City of Portland, Maine - Building or Use Permit Application
 389 Congress Street, 04101 Tel: (207) 874-8703, Fax: (207) 874-8716

Permit No: 06-0625	Issue Date:	CBL: 342 B024001
------------------------------	--------------------	----------------------------

Past Use: Vacant Land	Proposed Use: Single Family 26 x 36 2 story w/ garage	Permit Fee:	Cost of Work: \$130,000.00	CEO District: 5
Proposed Project Description: 26 x 36 2 story w/ garage		FIRE DEPT: <input type="checkbox"/> Approved <input type="checkbox"/> Denied	INSPECTION: Use Group: Type	
		Signature:	Signature:	
PEDESTRIAN ACTIVITIES DISTRICT (P.A.D.)				
Action: <input type="checkbox"/> Approved <input type="checkbox"/> Approved w/Condition <input type="checkbox"/> Denied				
		Signature:	Date:

**LOT 6 JOINT UTILITIES PLAN**

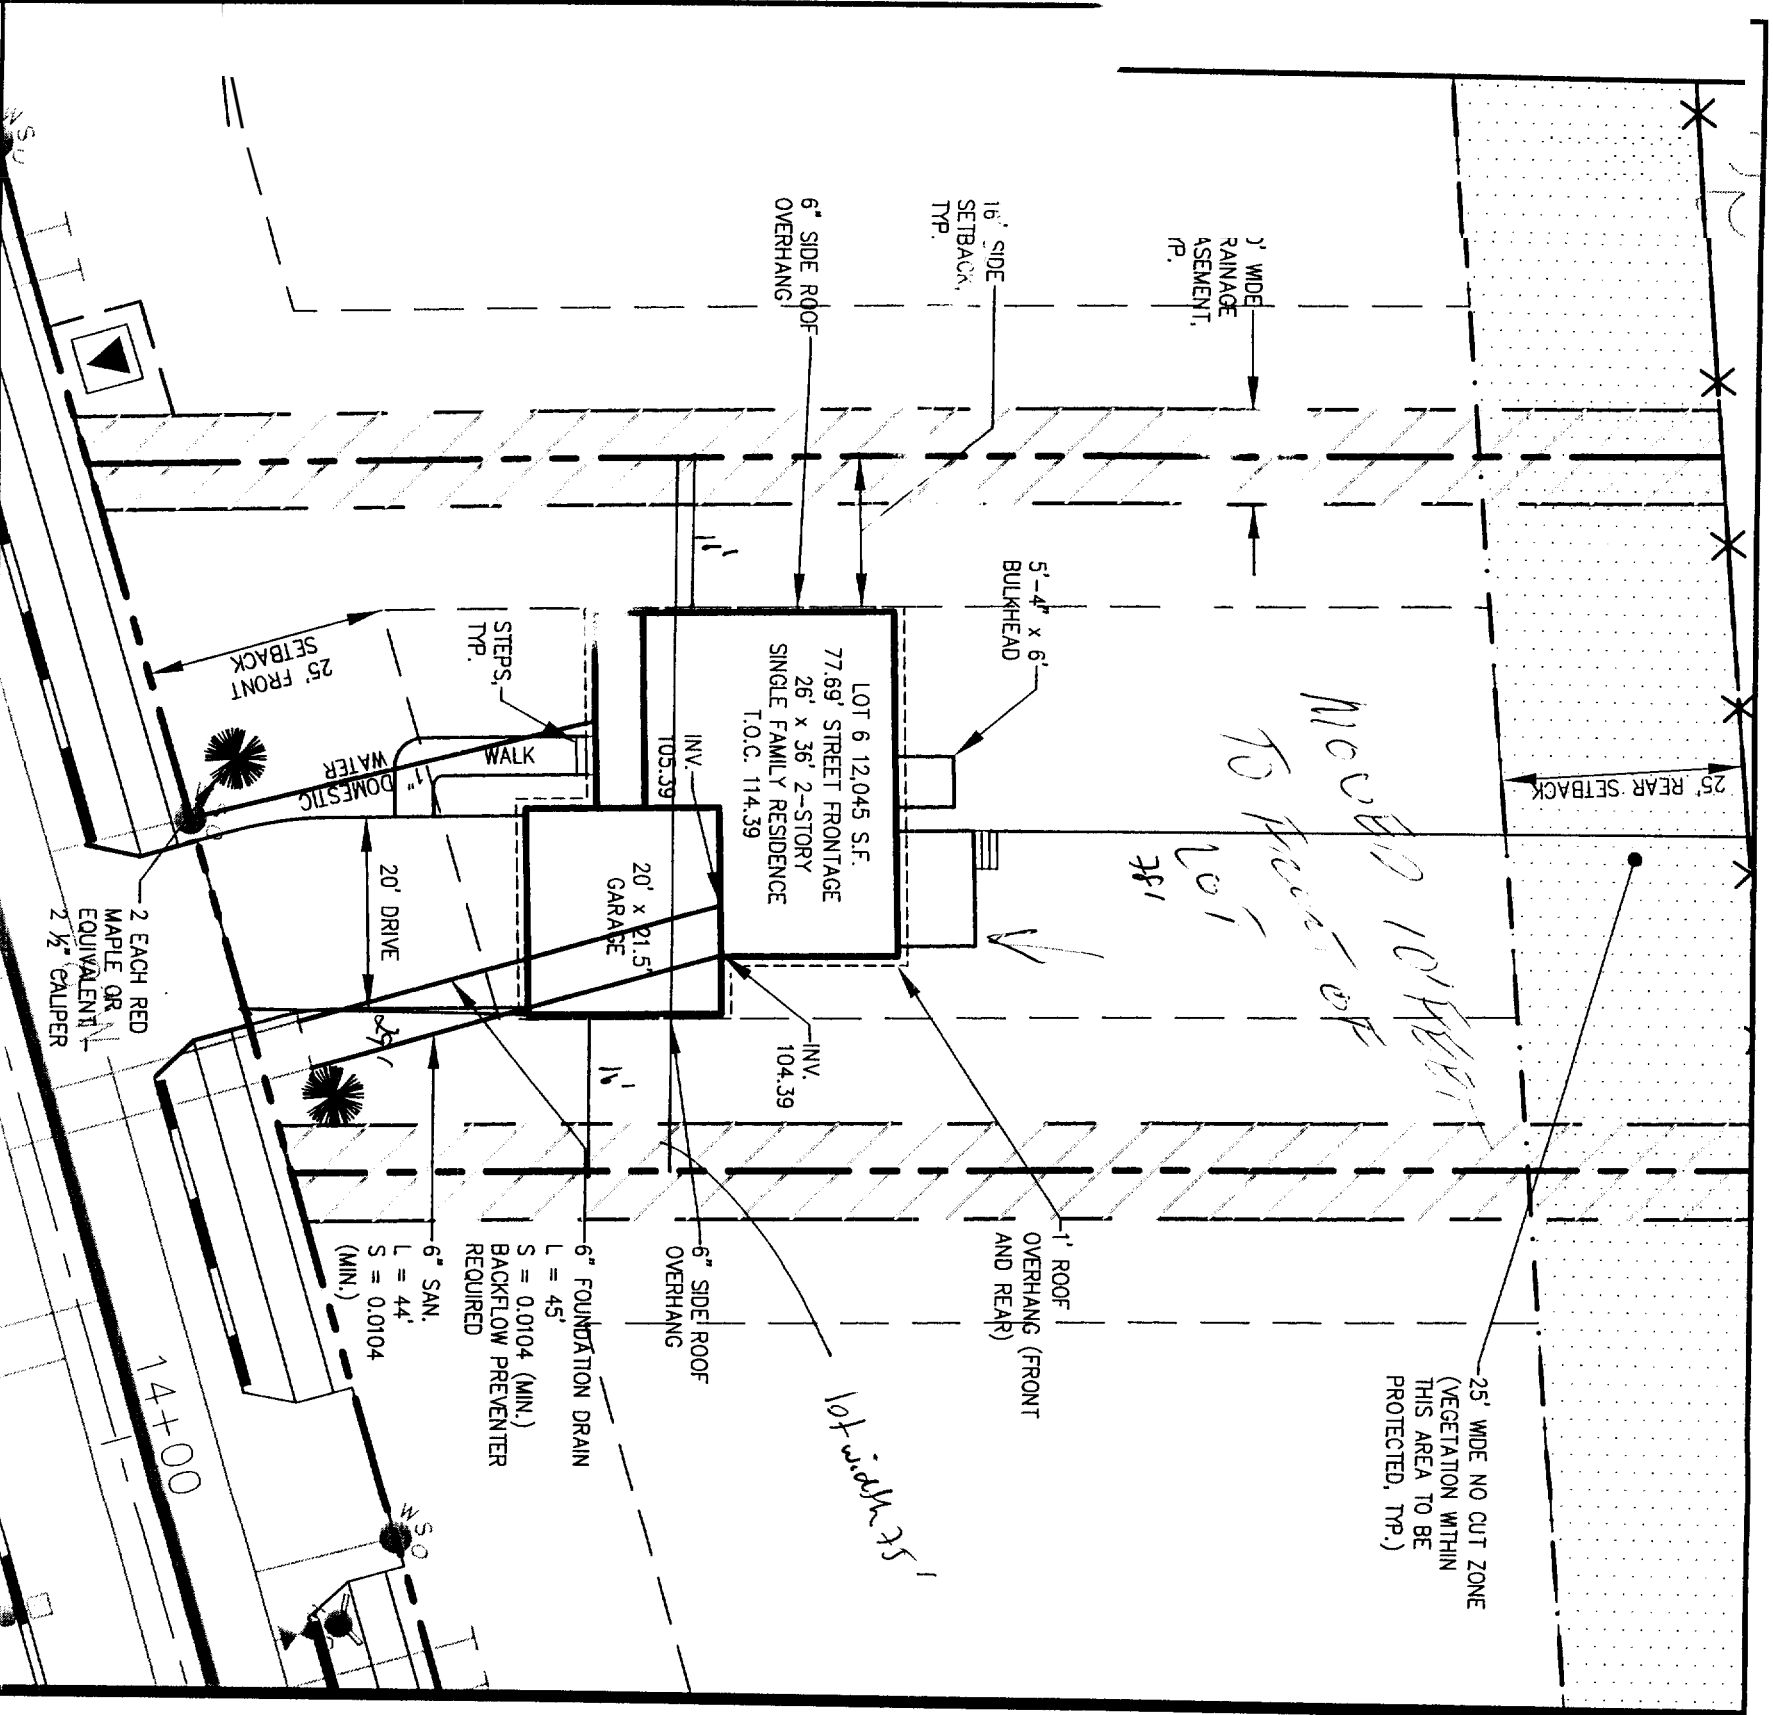
5/15/06-amachado: Left message with Dwight. Discrepancies between site plan & building plans.

5/18/06-GG: Received revised site plan. /gg

5/22/06-amachado: Dwight came in and revised the building plans to match the site plan
